Laurie Leader - RE: BP#2014-01486 106 Douglass Street - Plan review comments

Subject: BP#2014-01486 106 Douglass Street - Plan review comments

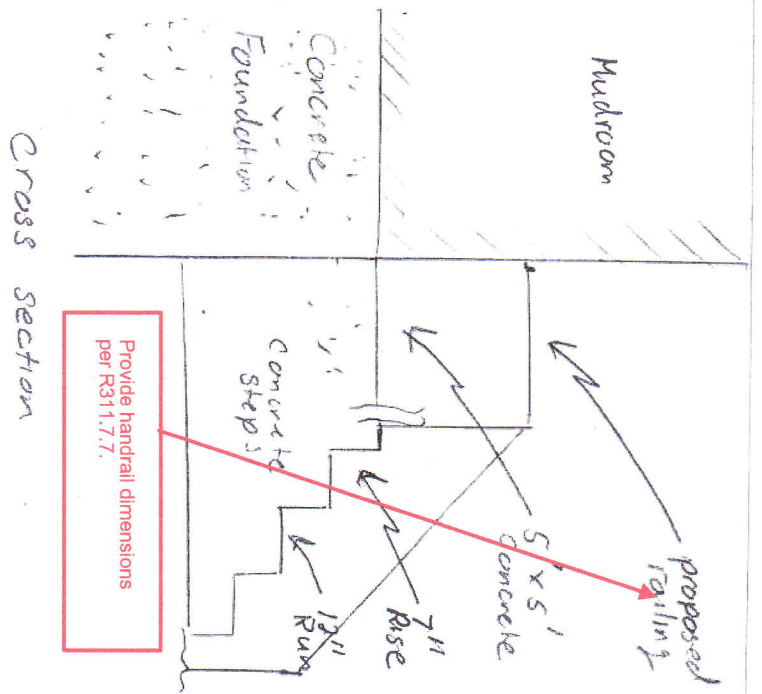
1. Can you please revise the handrail height per IRC 2009, handrail height shall not be less than 34" and not more than 38".
2. Provide header information for door going from the proposed mud room to the existing house. Provide

1. I have changed the rail height to 36".
2. Drawing 1B now shows header information. Please see connection details where mud room attaches to existing house.
3. Please see attached explanation on bulkhead.
4. Please see attached footing information.

Header Detail going from mudroom  
to existing House

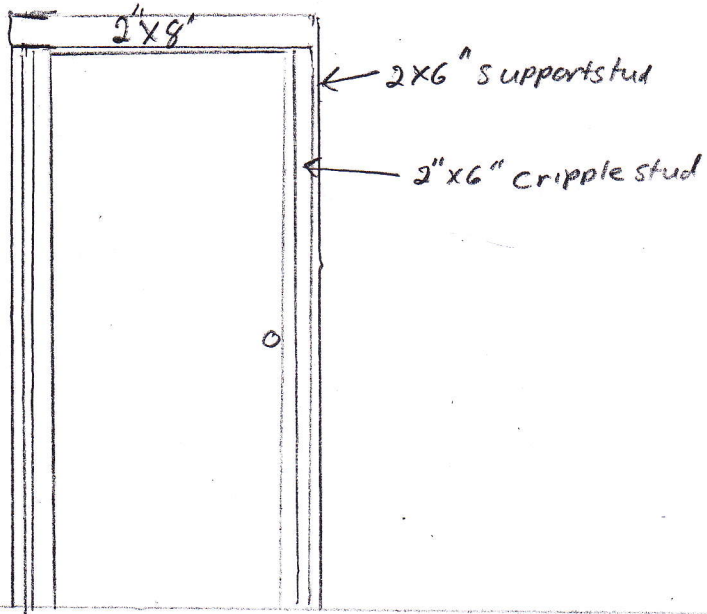
framing detail where mud room attaches to the existing house.
